From: Ancient Monuments Society [ancientmonumentsociety@btconnect.com]
Sent: 07 May 2013 20:31
To: Jane Tucker
Subject: Re: Consultation on planning application 3/2013/0294 Park House Farm, Bolton by Bowland
Thankyou for your consultation.

Please can we have your comments on the above planning application? It is for the proposed refurbishment of defective materials and structure at Park House Farm, Bolton by Bowland. I have attached the formal consultation letter and here is a link to view the submitted documents and listing description on our website <http://www.ribblevalley.gov.uk/planningApplication?appNumber=3%2F2013%2F0294&submit=Go>

PARKHOUSE FARM
BOLTON BY BOWLAND
GROUND FLOOR LAYOUT
SCALE 1:50 @ A3

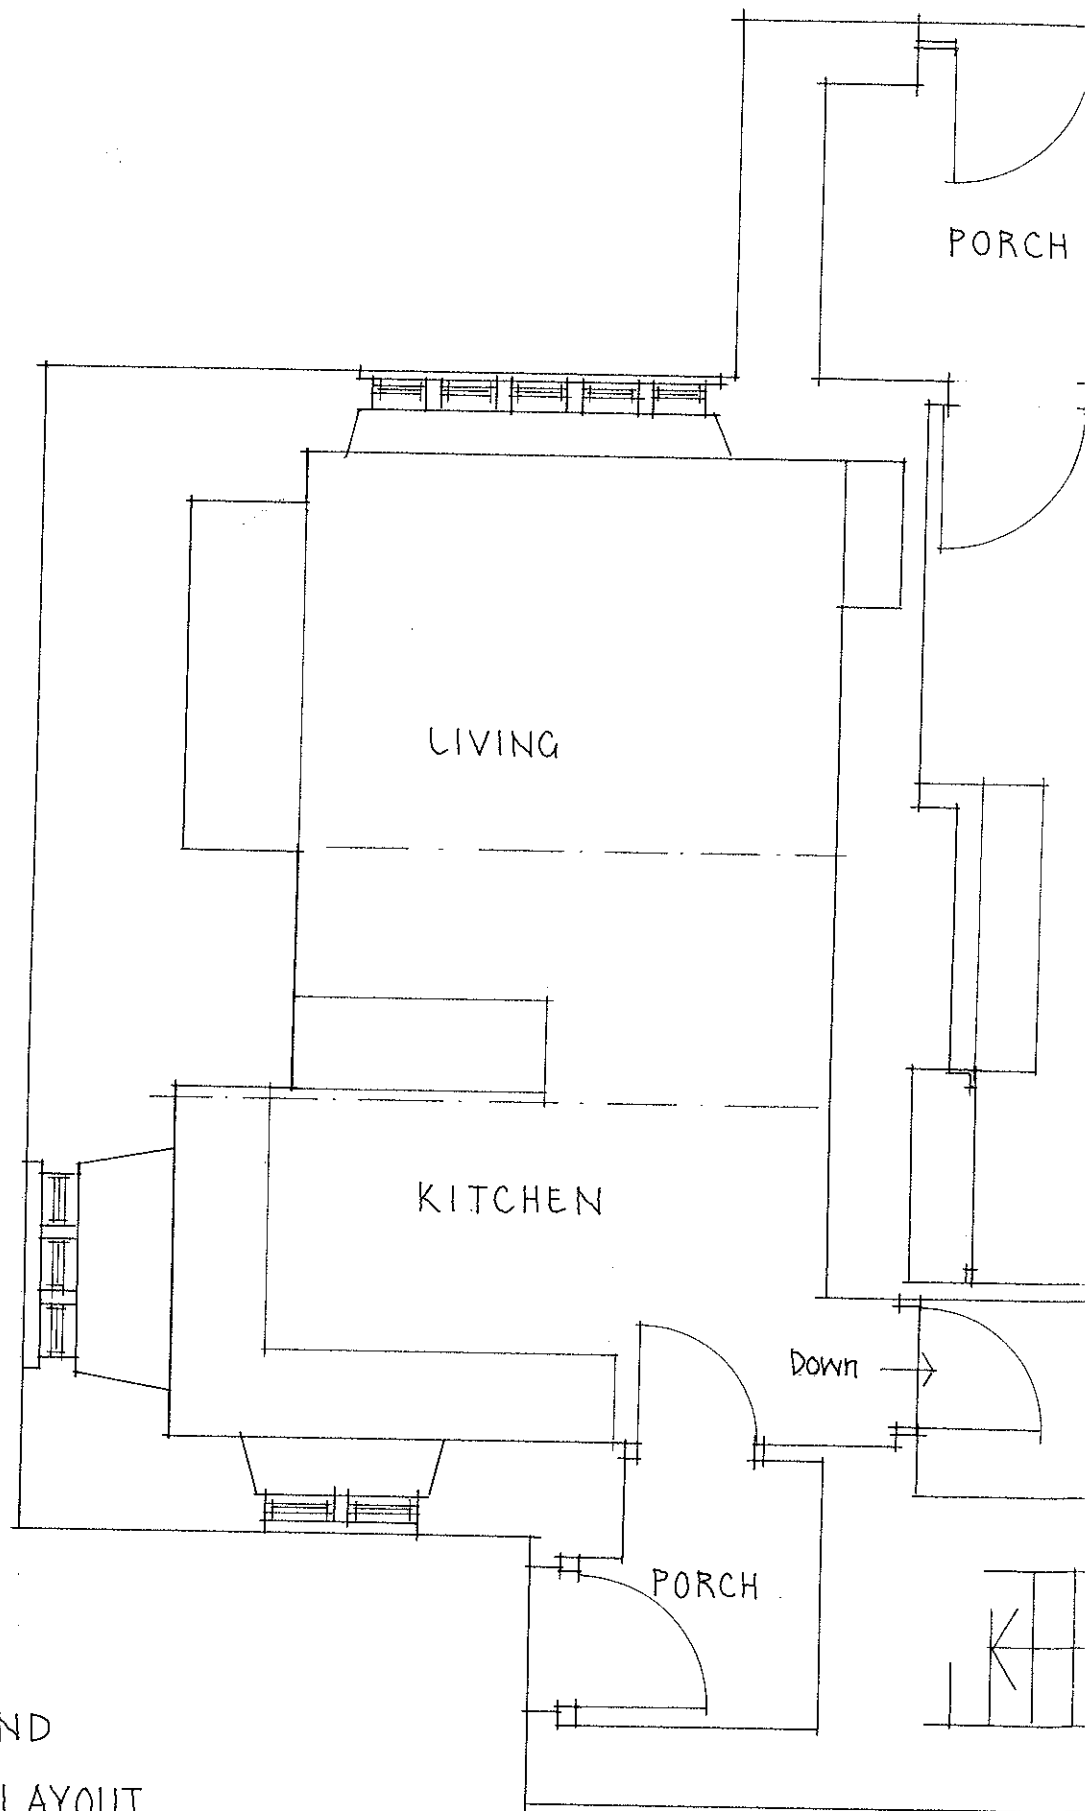
We are quite prepared to defer to Adrian Dowd but we do urge caution on some of the proposals as described - particularly the replacement of wooden floors with concrete and the treatment of stone lintols where the presumption should lie with repair rather than replacement.

Also we must be concerned where a staircase is condemned without first removing the carpet which conceals so much of it
